City of Albuquerque Stormwater Construction Site Inspection Report

ESC File No.	G11E069	Project Name:	Coors Pavilion		
NPDES Id. No.	NMR10052A & 52U	Location:	St Josephs St. NW		
9/21/2022	Owner	Contractor NMR10052U			
Operator	Red Shamrock 4, LLC	Scarsguard Construction, LLC.			
Contact name & title	Josh Skarsguard	Jason Skarsguard			
e-mail	Josh@scarsguardfirm.com	jason@scarsco.com			
Contact Phone #	262-2323	803-3757			
COA Inspector	Doug Hughes	Start/End Time:	9:30-11:00 AM		
Construction Phase:	Staging				
Type of Inspection:	Regular	Storm Event	Past Storm Event >0.25"	311/Complaint	Follow Up
Weather at time of inspection?		Cloudy	Temperature: ~		76
Estimated date of last storm 0.25" or greater		8/18/2022

The following conditions were observed during a City follow-up inspection on 9/21/22.

AMENDMENT FOR MASTER DRAINAGE PLAN

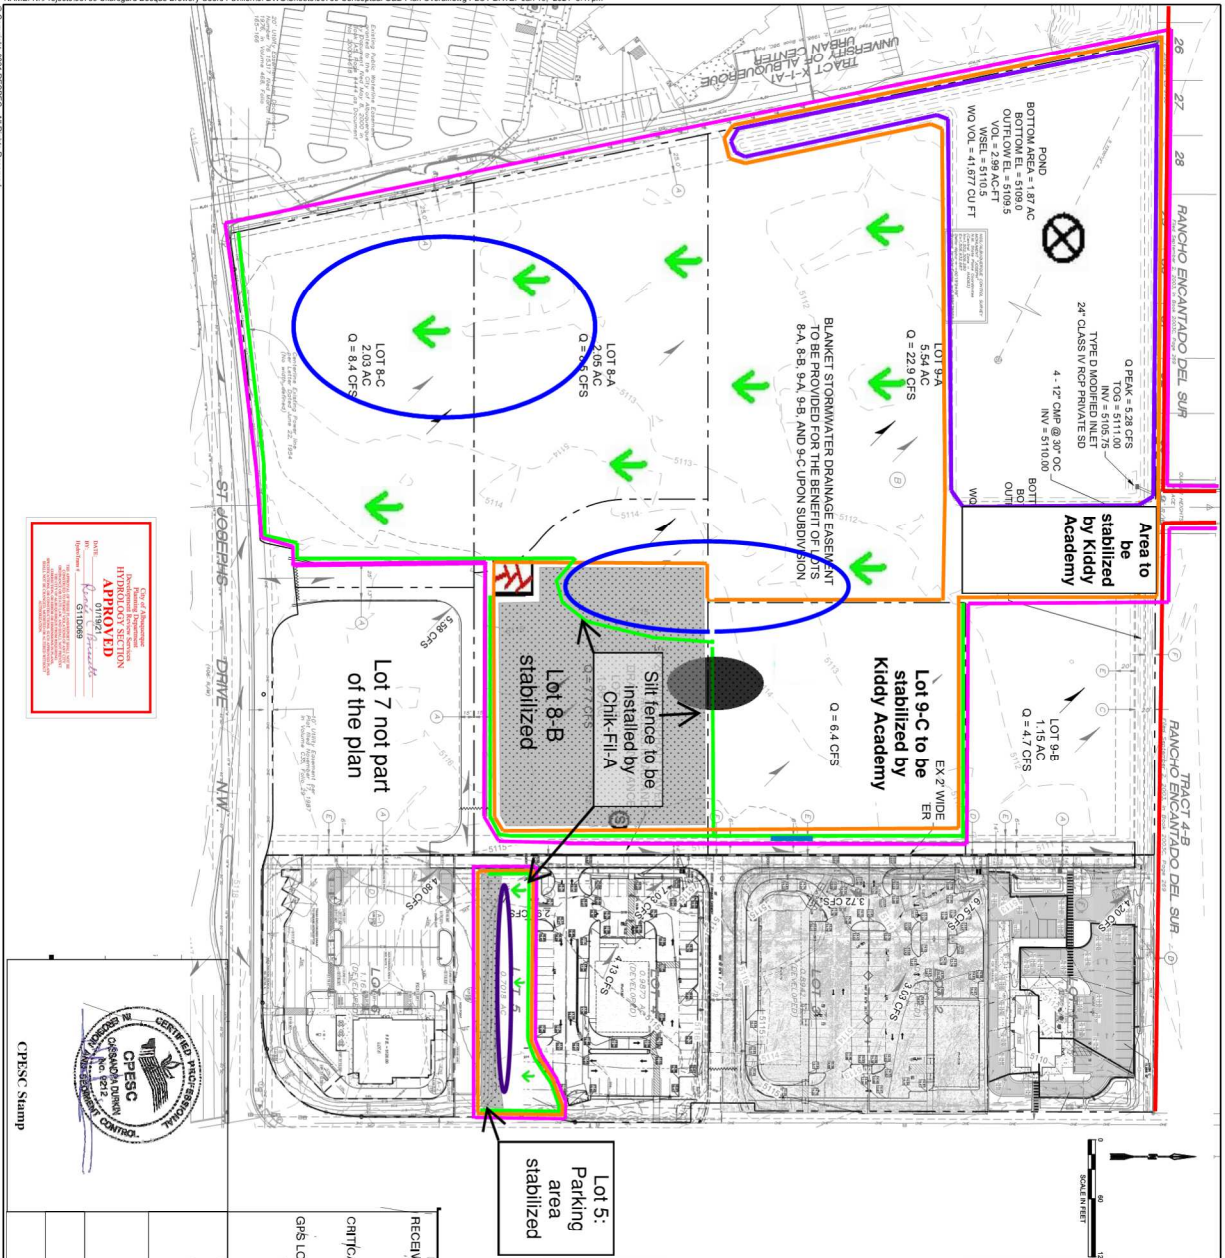
The 2017 Permit Coverage NMR1000FN expired at the end of the 2017 CGP. A new NOI was filed on 8/31/22, and permit coverage was posted in the middle of the property, not visible from any public street. Lots 8C and 9C are still covered by mostly bare dirt, but a small area near Chick-fil-a was recently covered with gravel. There isn't any change to the BMPs or sediment in the street. Neither the ESC Plan nor the NOI's have been submitted to the City for approval. Both the owner and contractor are operators with coverage under both the 2017 and 2022 CGP. They both signed the certification statement in the SWPPP and Delegated Authority to Trish Kvern Trish@retailsouthwest.com, 505-262-2323, who has the SWPPP at 8220 San Pedro DR. NE STE 500. The SWPPP doesn't have any Inspection or Corrective action reports in it, nor does the SWPPP Map show current site conditions. The map has the engineer's stamp
